EPC STORMWATER REVIEW COMMENTS  
IN ORANGE BOXES WITH BLACK TEXT

# GRADING AND EROSION CONTROL PLAN

## FOR 168 TRAINING FACILITY

## GRADING & EROSION CONTROL PLAN COVER SHEET

**GRADING & EROSION
CONTROL PLAN
GRADING PLAN**

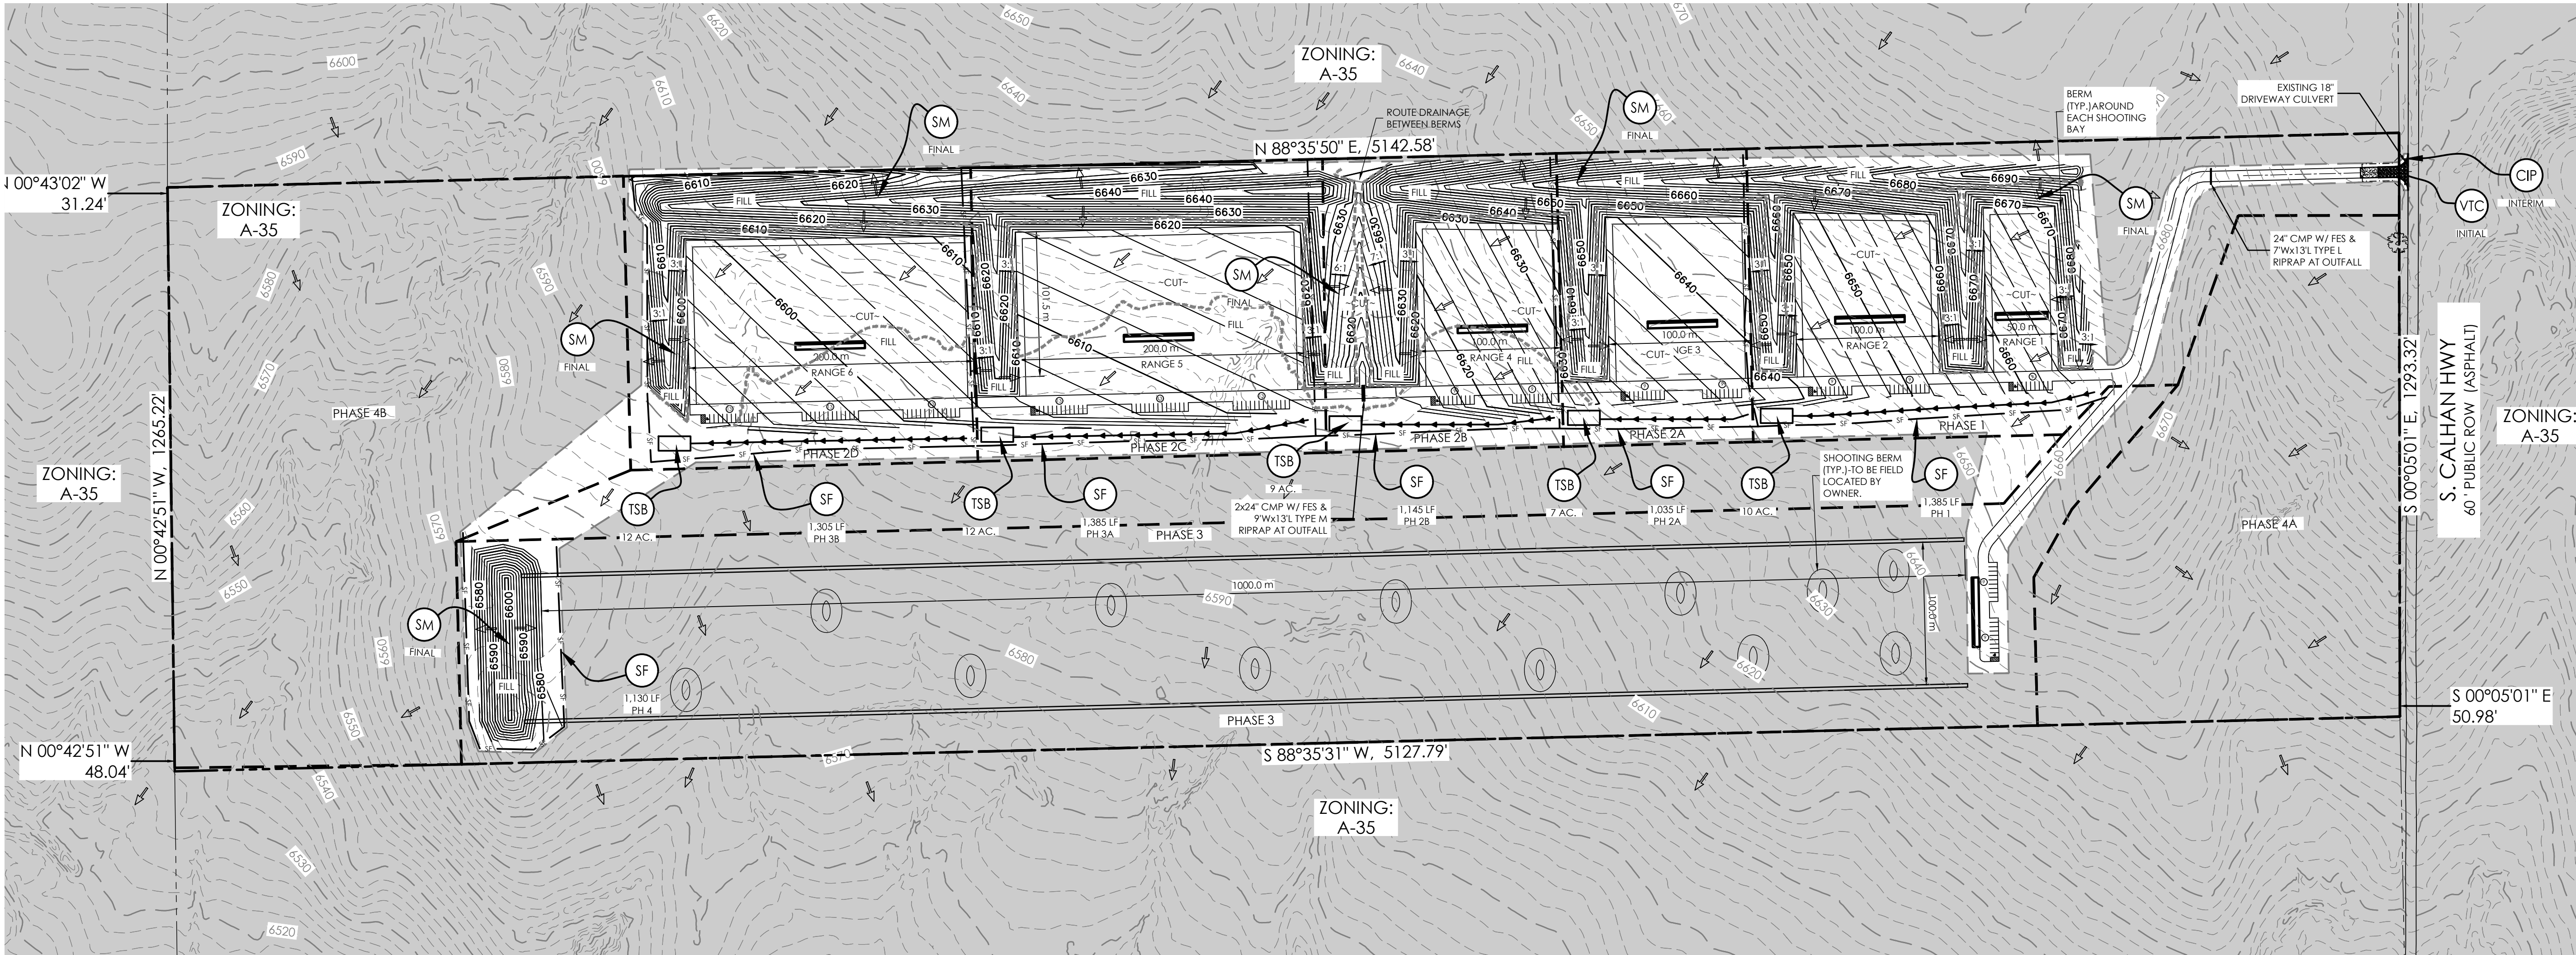
GEC Checklist item p - identify areas of cut/fill  
 GEC Checklist item s - show stormwater flow direction arrows  
 GEC Checklist item x - Provide TSBs for disturbed areas greater than 1 ac

Please provide ditch sizing including minimum depth required.

Callout proposed culvert size and inverts. Provide culvert calcs in the drainage report and riprap at the outfall as needed for erosion protection.

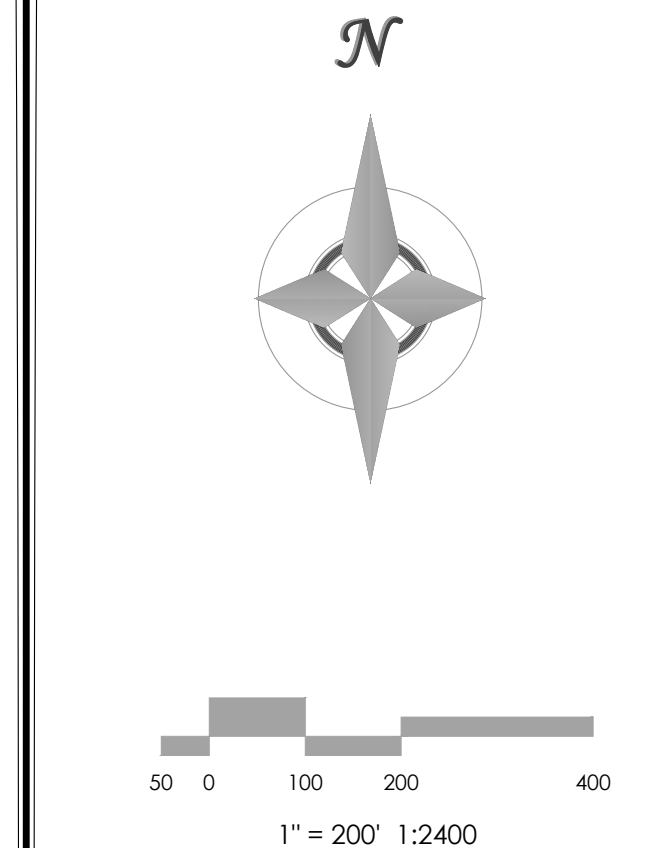
Replace with EPC approved VTC detail (VT-1 and VT-2 in DCMv2, Chap 3.3) or revise to be 75ft min length.
